Tel: 01903 737756
Email: planning@arun.gov.uk
www.arun.gov.uk/planning
Please ask for: Ms Ella Summerfield
Email: ella.summerfield@terraquest.co.uk
Telephone: 0121 2341390
Our Ref: M/64/26/HH
Your Ref:
Date: 24th September 2026

Application for Planning Permission for Works or Extension to a Dwelling

Development: Single-storey front, side and rear extensions, alterations to existing roof terrace, replacement windows and doors, new solar panels, external alterations and associated works.

Location: 5 Sea Way Elmer Middleton-On-Sea PO22 6JX

Dwg. No. E-001
 Title: Location and Site/Block Plan
 Address: 5 Sea Way, Elmer, Bognor Regis PO22 6JX
 Client: Mr and Mrs Pallister
 Scale: Stated@A3
 Stage: PLANNING
 Drawn: PS
 Date: August 2025

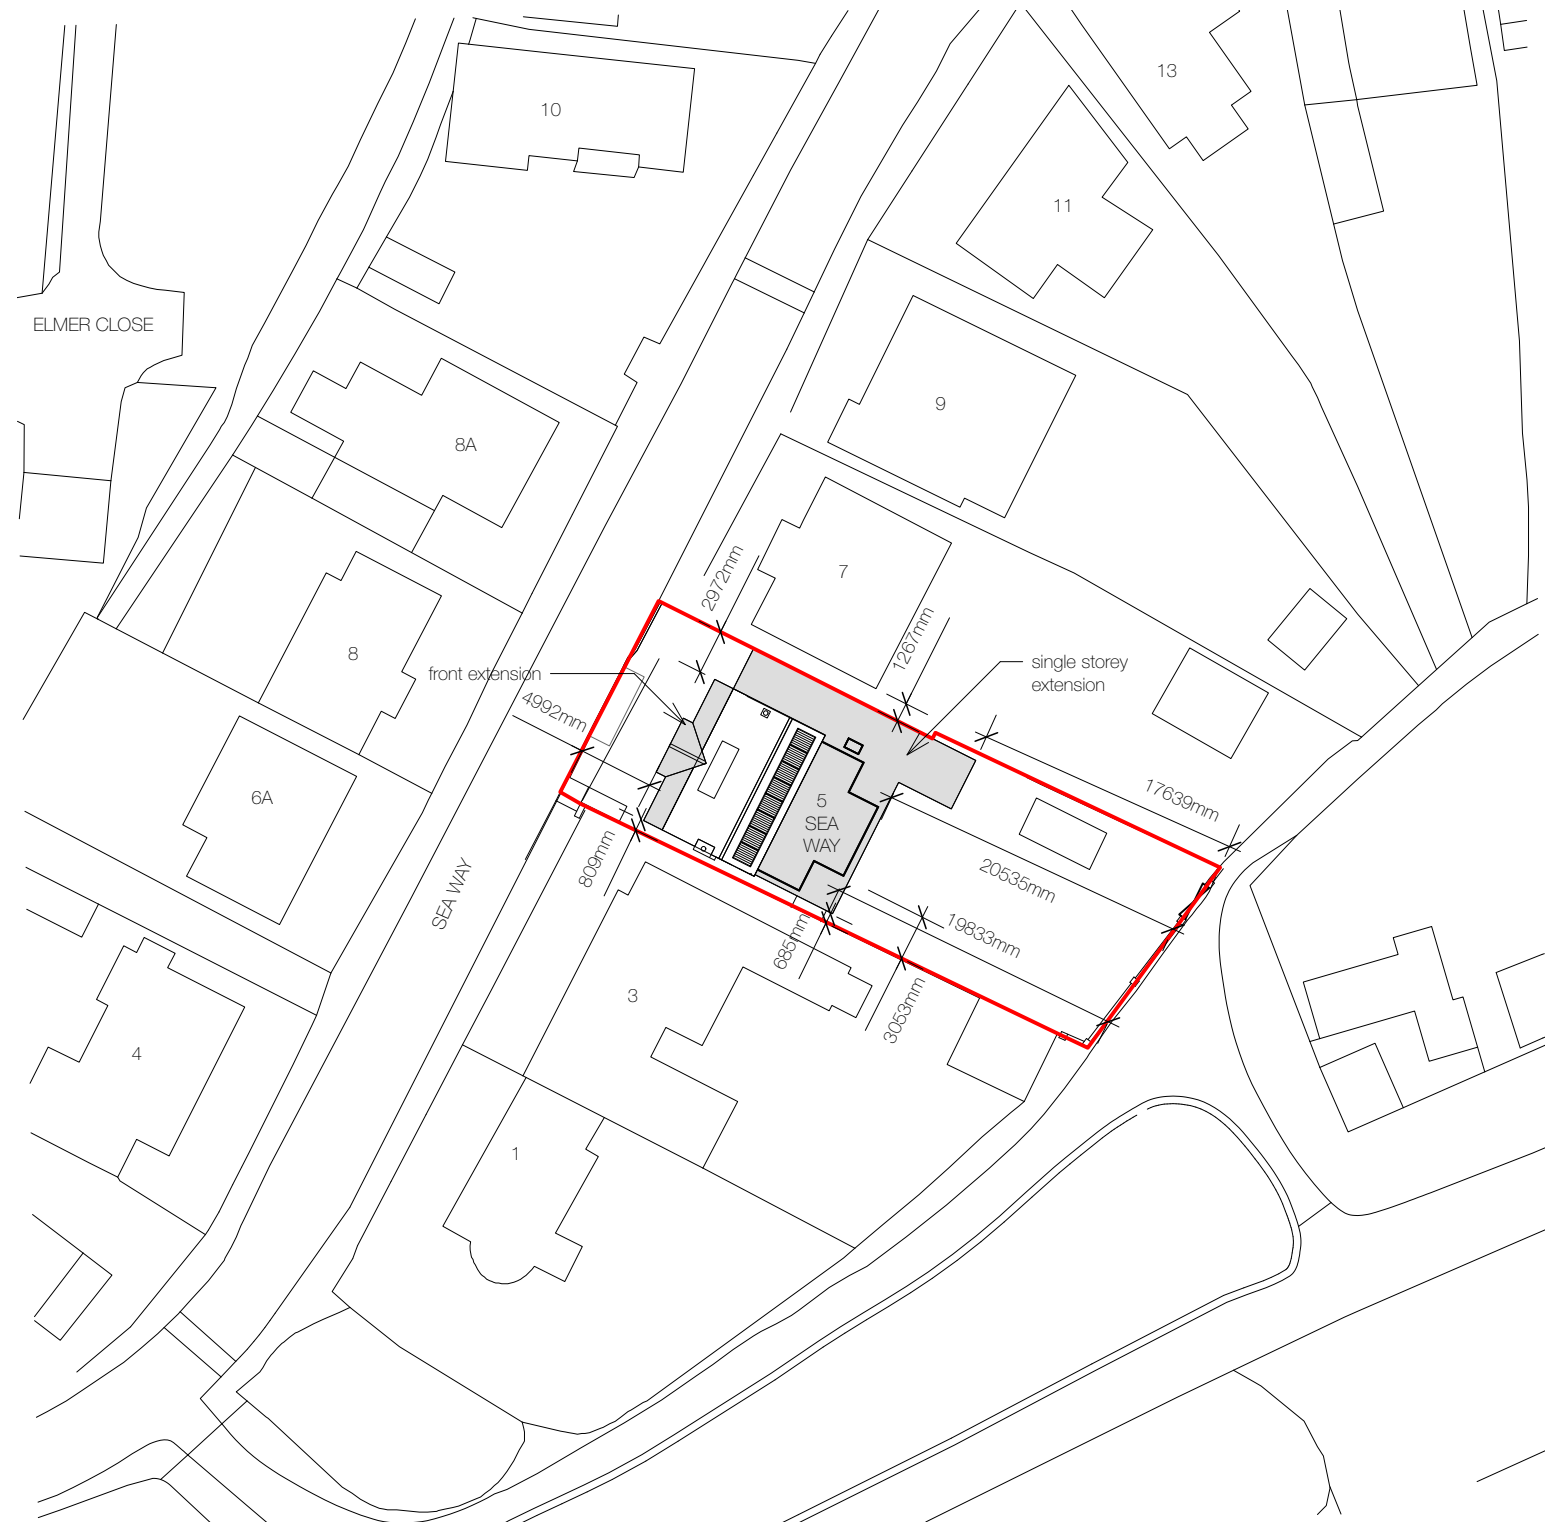
There are hedges visible in the existing site plan which are not visible in the proposed site plan. This means that the trees and hedges section in the application form needs to be ticked "yes".

Proposed Roof Plan

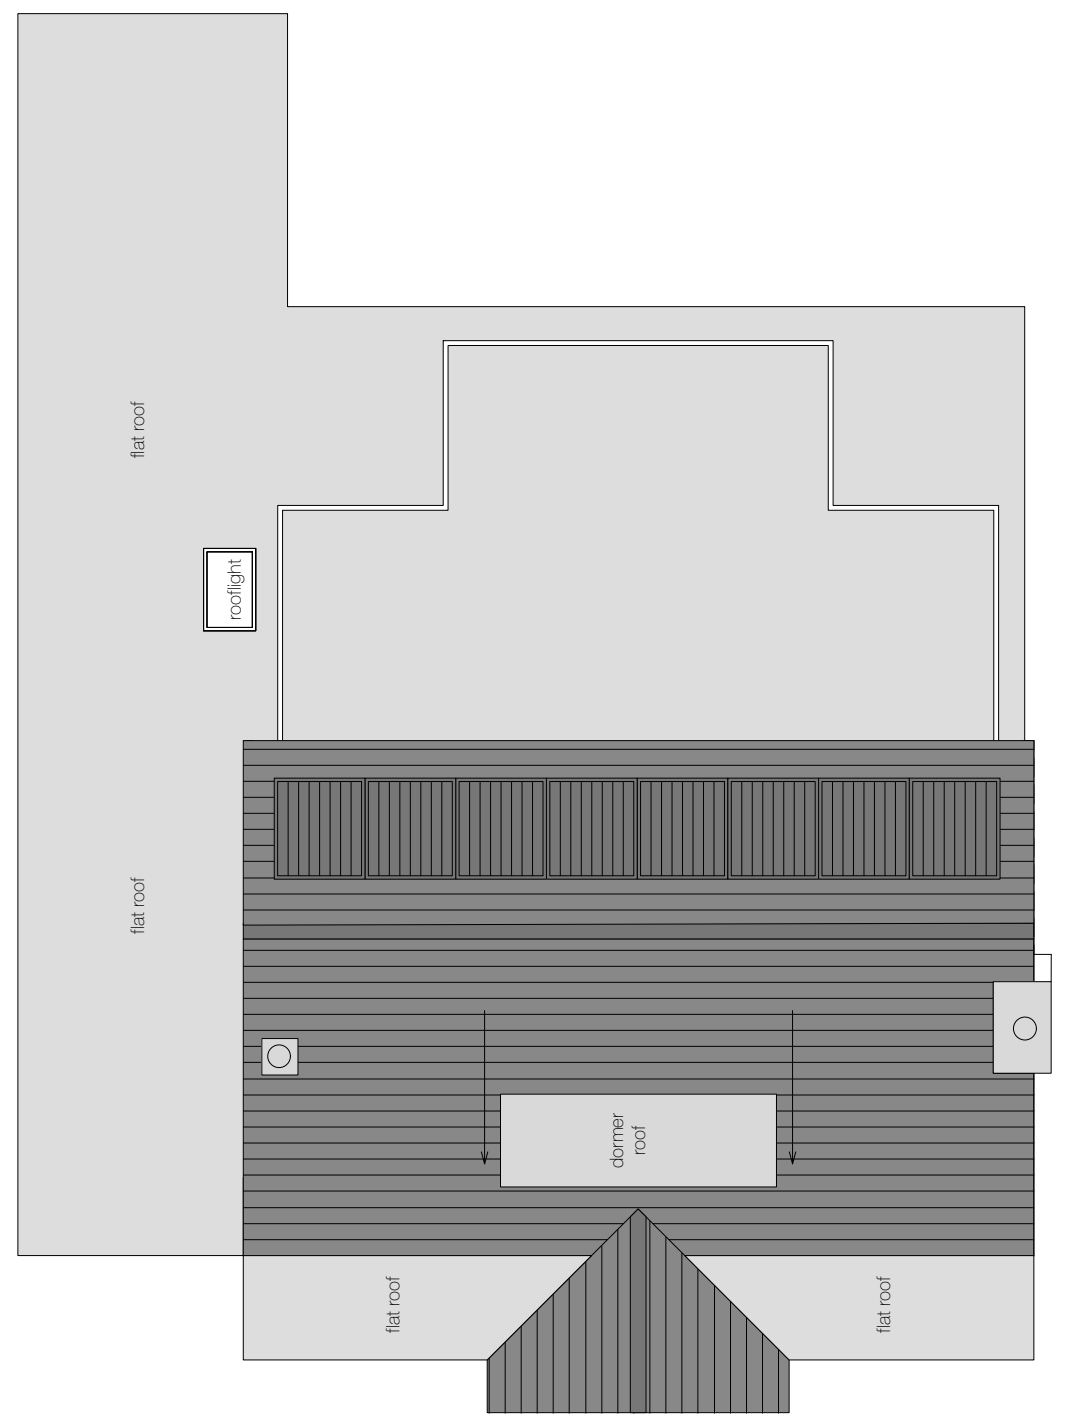
Please add the solar panels to your description of works, or with your permission, we can add this for you.

Information for the solar panels need to be provided either to us or the planning officer.
